SCOPING OPINION:

Proposed Grand Union Canal Transfer

Case Reference: WA0210001

08 May 2025

Figure 3-4: Part 1a Minworth AWTP Indicative Layout Plan

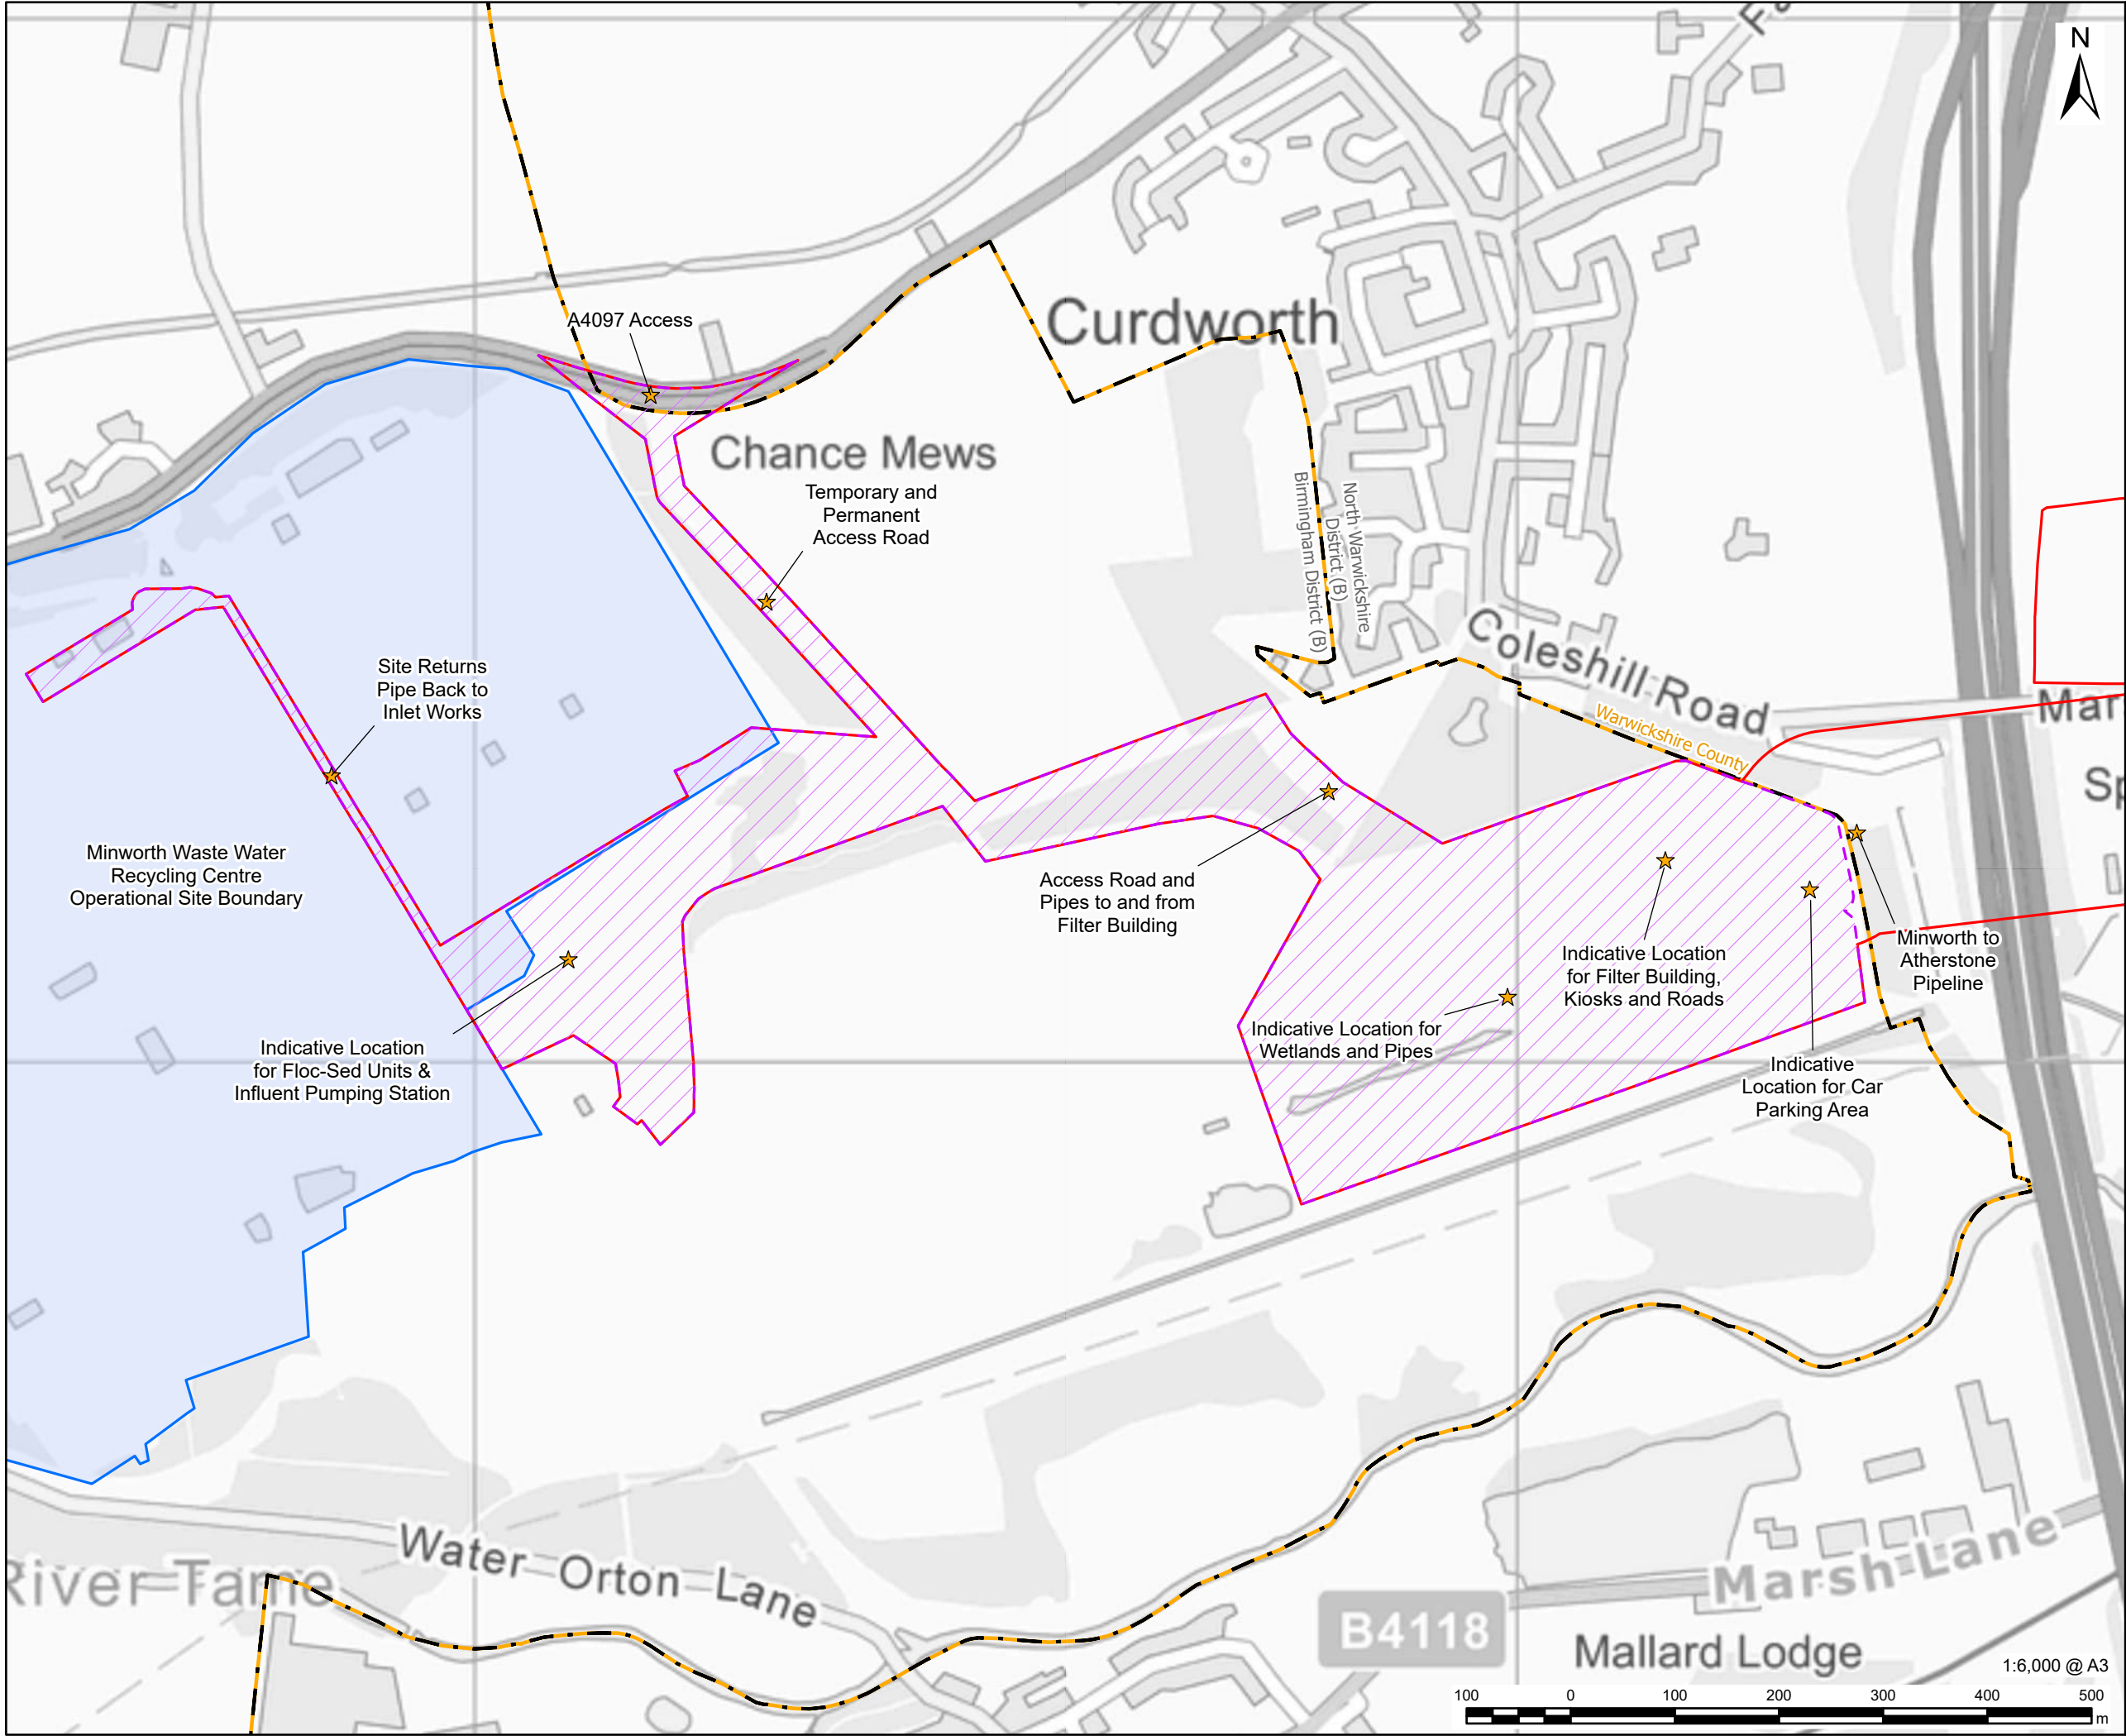
ID	Ref	Description	Inspectorate's comments
214	Paragraph 3.5.6 and figure 3.4	Building parameters	The indicative location of the Minworth Advanced Water Treatment Plant (AWTP) is shown on figure 3.4 and paragraph 3.5.6 and states that the AWTP will be no higher than 15 metres. To ensure a robust assessment of likely significant effects, the ES should include a full and detailed description of any built structures for which development consent is sought, including the location, maximum length, width, height. The ES should include cross reference to relevant aspects such as landscape.
215	Figure 3.6 sheets W, X and Z. Figure 1-1 sheet E	Red line boundary	Figure 3.6 sheets W and X show large areas of land identified as being in the red line boundary, but it is not entirely clear what is proposed for this land. Figure 1-1, sheet E, shows these may be the locations being considered for the abstraction, storage and treatment plant. To aid understanding of plans, the ES should ensure that all parts of the proposed development are clearly presented on accompanying figures and cross references provided within the main text to where features are shown.
